From: Anita Gardner
Sent: 07 May 2020 15:02
To: Planning.Responses
Subject: FW: FW: LU/59/20/PL - Vernon House, 10 Maltravers Drive, Littlehampton, BN17 5EY

From: Kate Giddings [REDACTED]
Sent: 07 May 2020 15:00
To: Anita Gardner <Anita.Gardner@arun.gov.uk>
Subject: RE: FW: LU/59/20/PL - Vernon House, 10 Maltravers Drive, Littlehampton, BN17 5EY

In relation to the above application, I note that section 20 of the application form has been completed 'N/A'; could the applicant please confirm whether this means that the proposed kitchen extension will not include additional and/or altered extraction/ventilation/air conditioning equipment?

Kitchen Extension Proposed
1 : 50

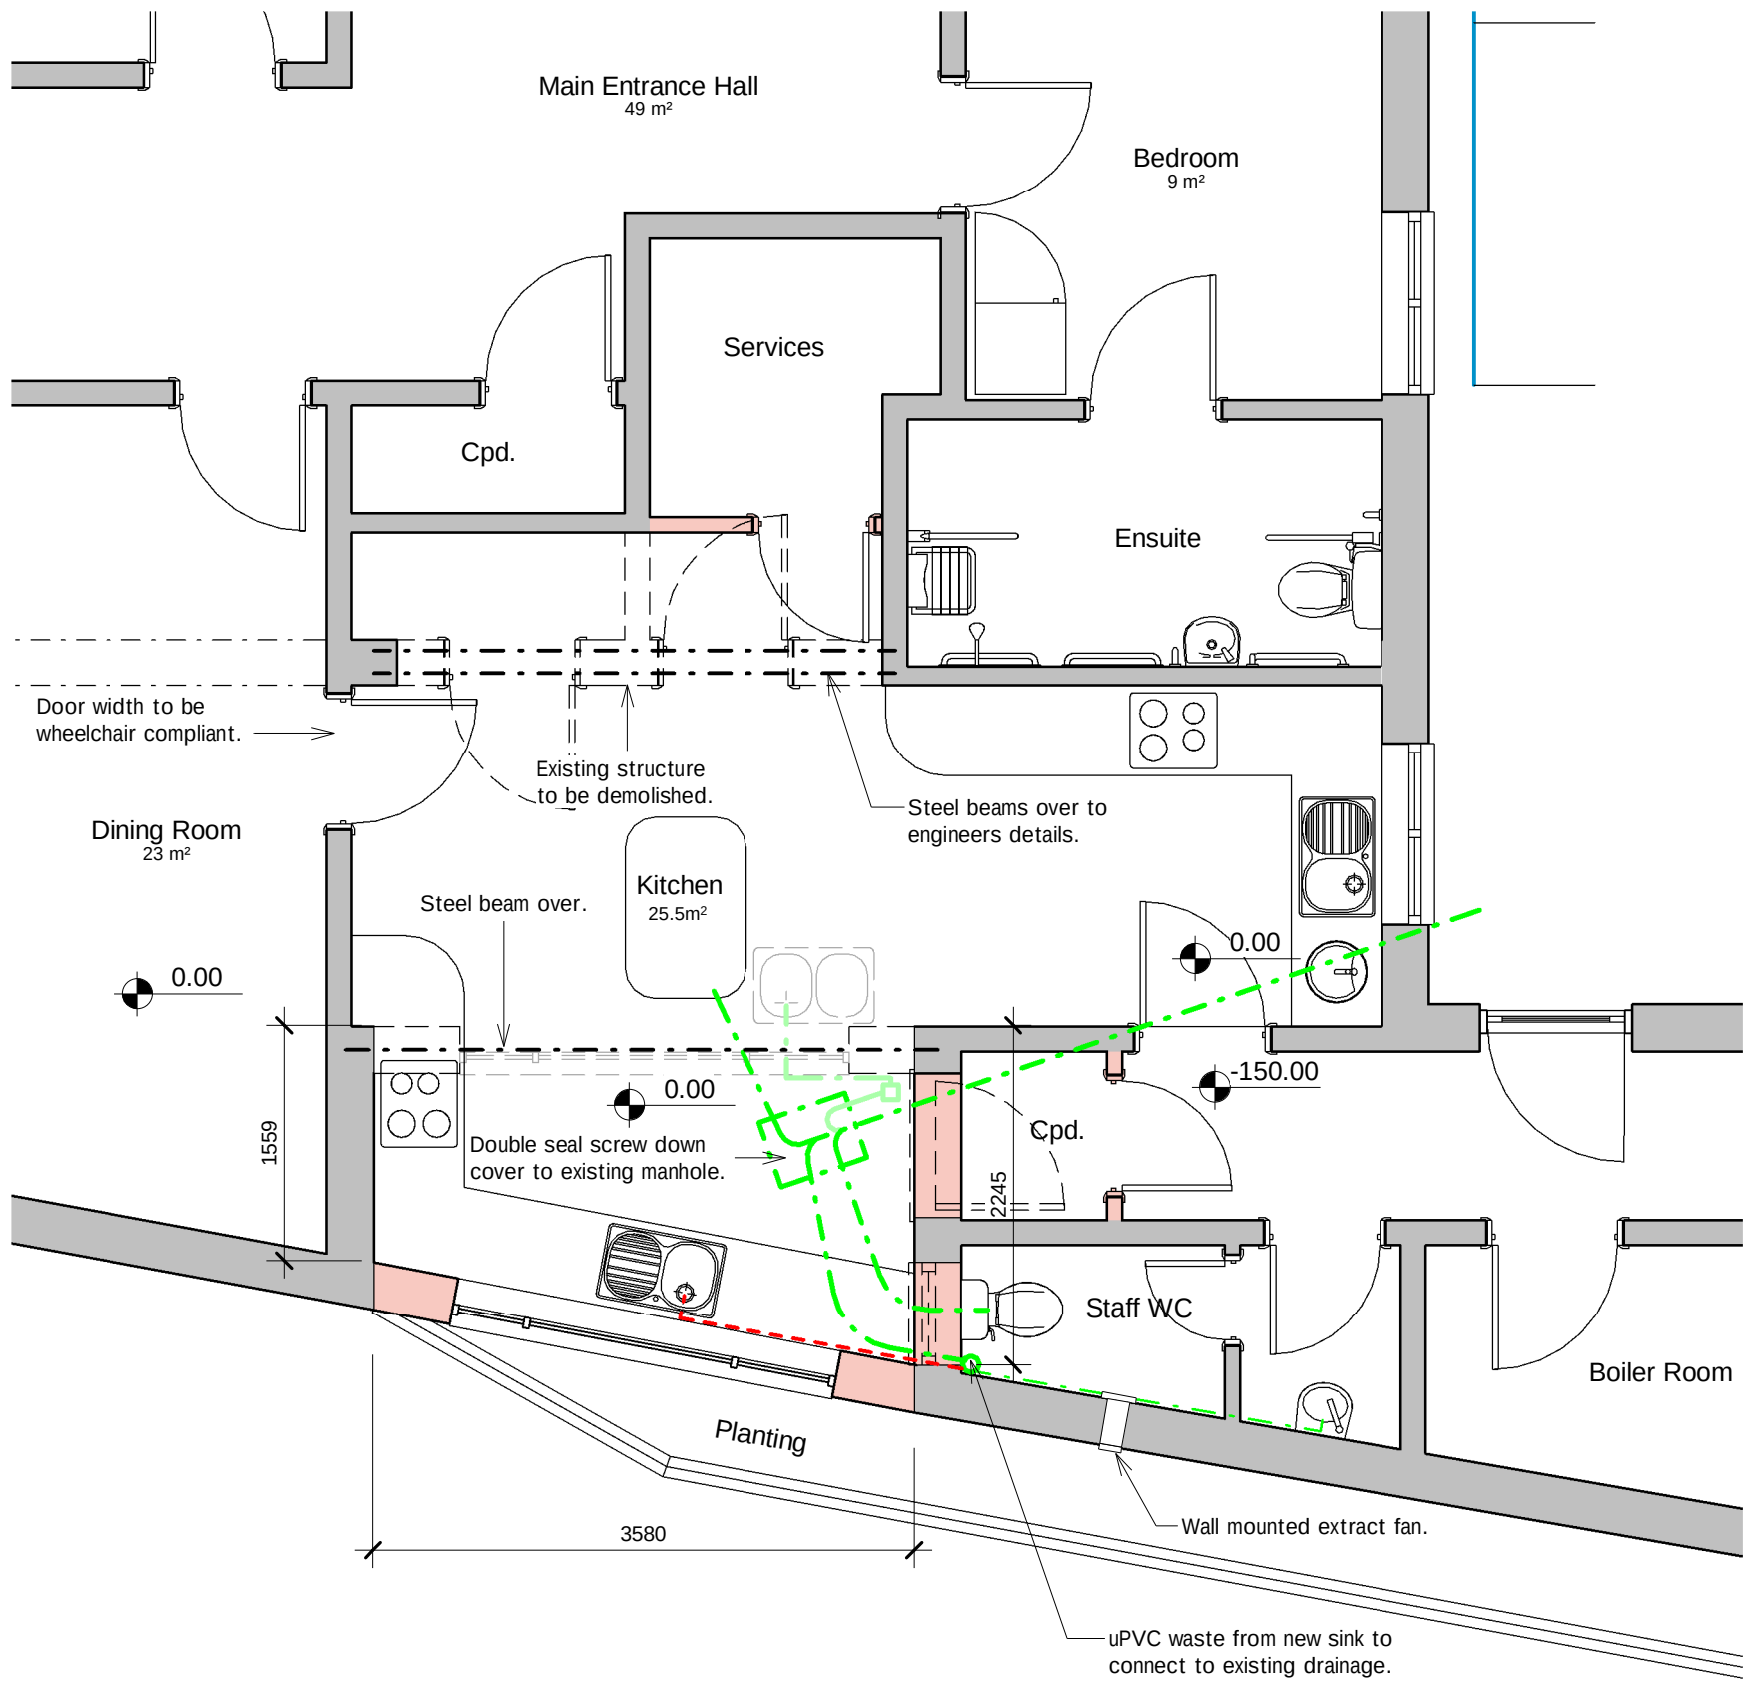
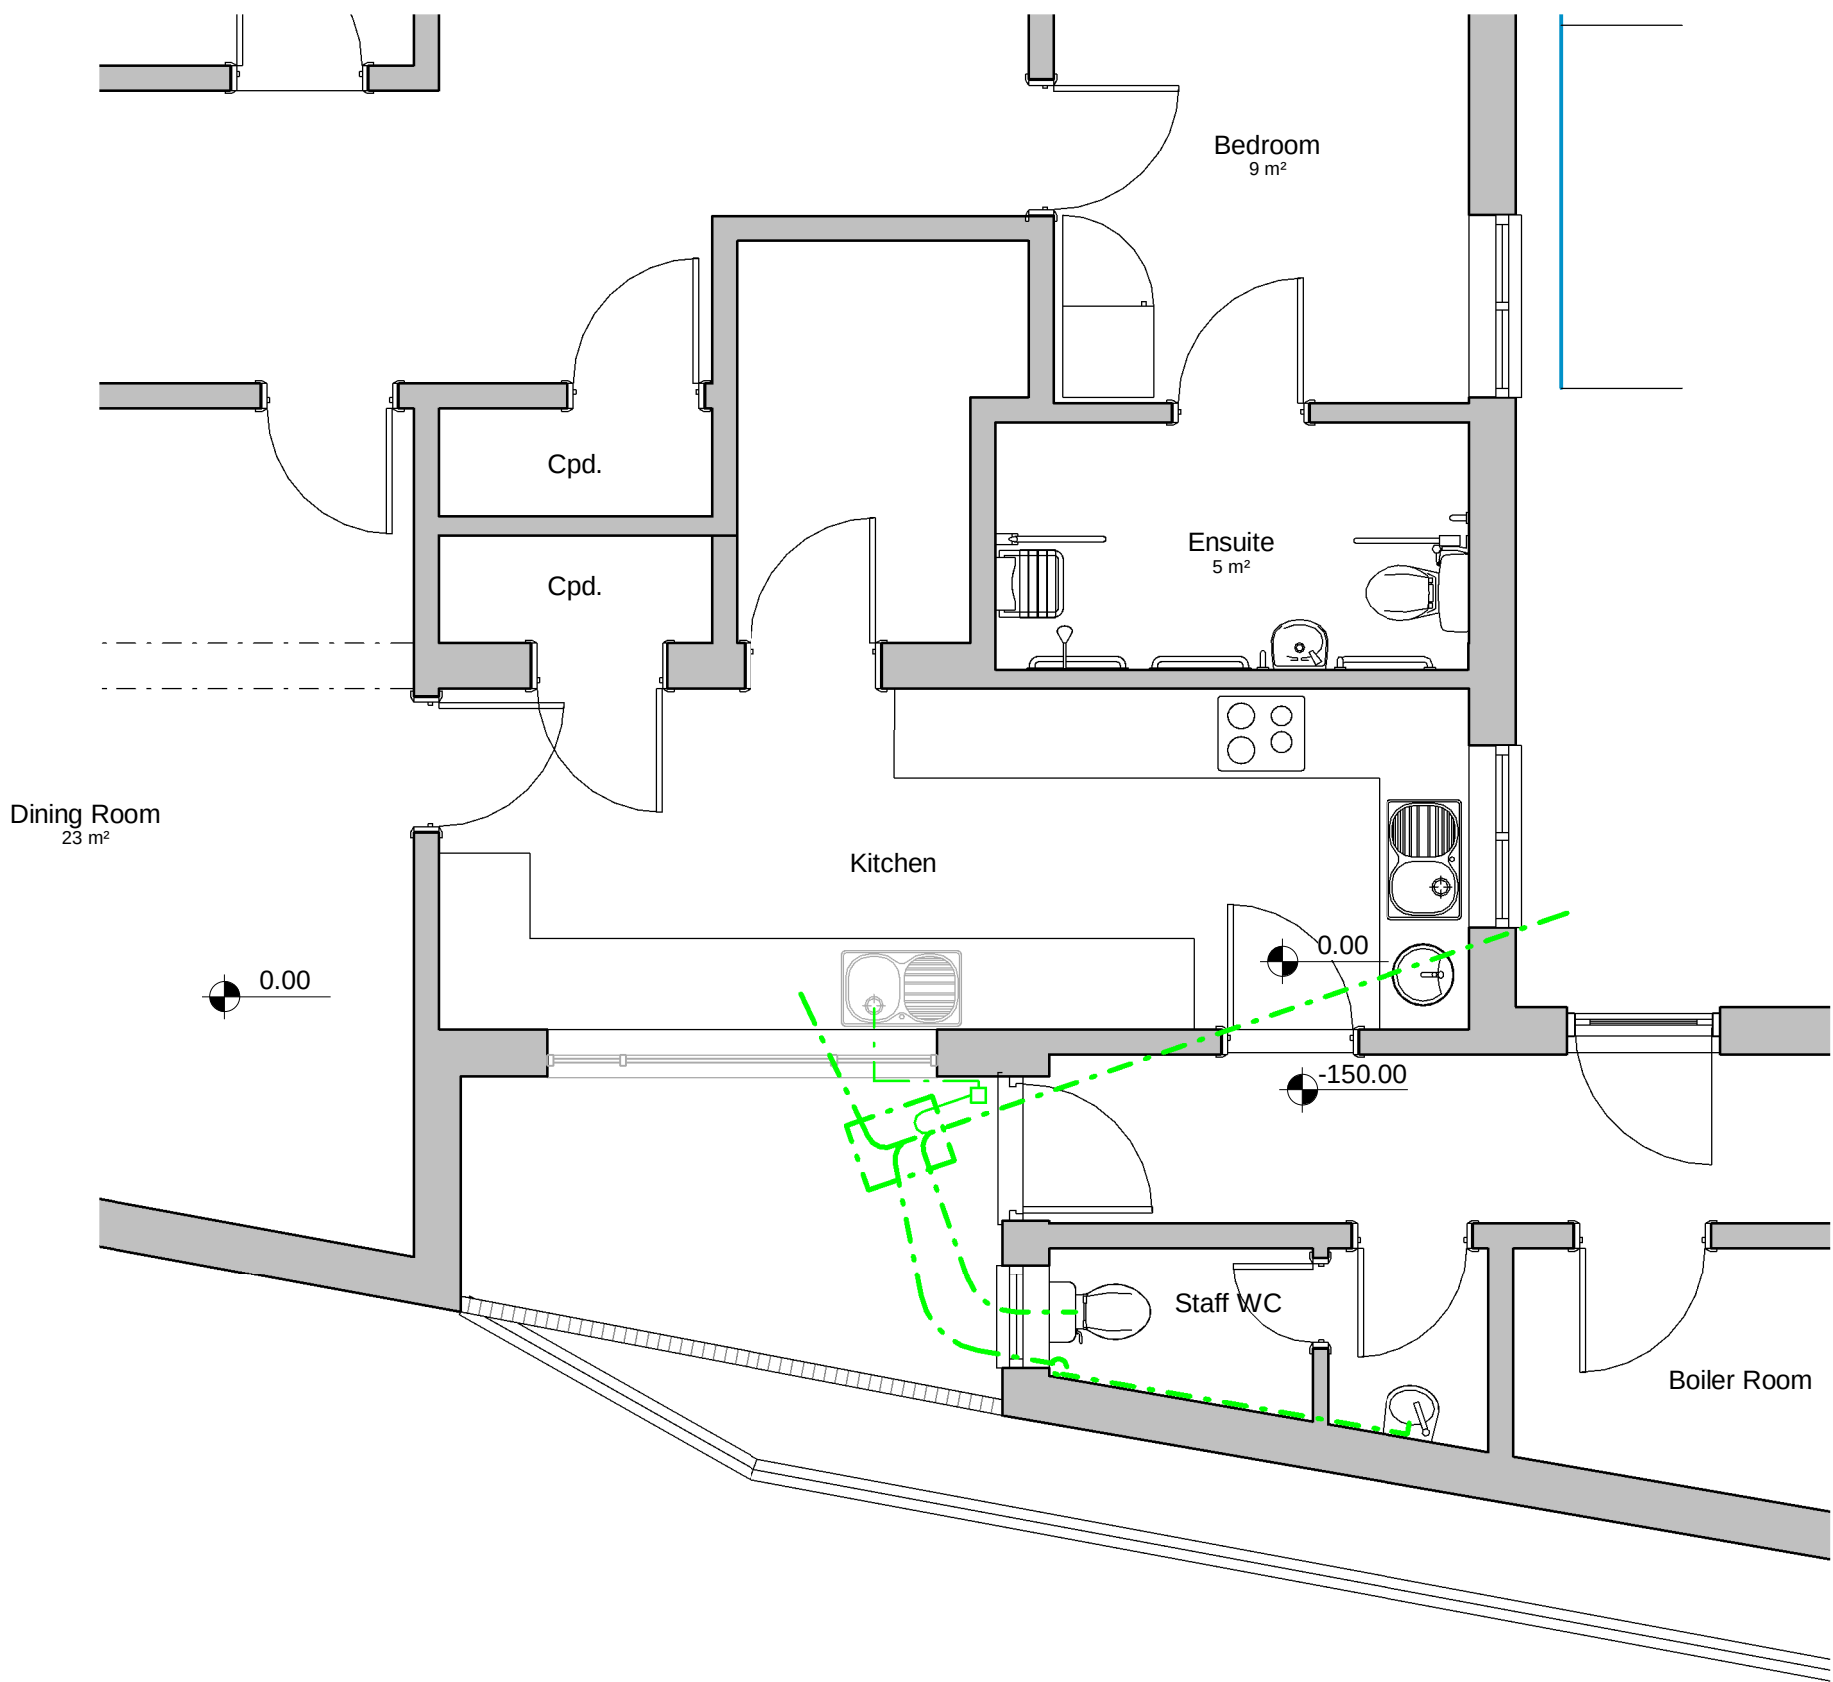
- Additional cooking appliances and associated equipment shall not be operated unless and until details of a suitable system for the extraction of cooking odours (including details of the extract fan units, filters, extraction hoods and ducting together with method of noise abatement) has been submitted to and approved in writing by the Local Planning Authority. The equipment approved under this condition shall be installed by a competent engineer before the use hereby permitted commences and thereafter shall be maintained in accordance with the manufacturer's instructions. **Reason:** To protect the amenity of local residents in accordance with Policy QE DM1 of the Adopted Arun Local Plan 2011 – 2031

I would appreciate confirmation within the next 10 days, that the proposed kitchen extension will not include additional and/or altered extraction/ventilation/air conditioning as a result of the proposal.

In response to your query, the existing cooker and extraction is to remain and if an additional cooker is required by the client there will be a domestic type extract/cooker hood installed to the following specification.

'Kitchen to have mechanical ventilation with an extract rating of 60l/sec or 30l/sec if adjacent to hob to external air, sealed to prevent entry of moisture. Intermittent extract fans to BS EN 13141-4. Cooker hoods to BS EN 13141-3. All fixed mechanical ventilation systems, where they can be tested and adjusted, shall be commissioned and a commissioning notice given to the Building Control Body.'

Please note that this is not a commercial scale kitchen, it is used solely to provide food for the small number of residents.'
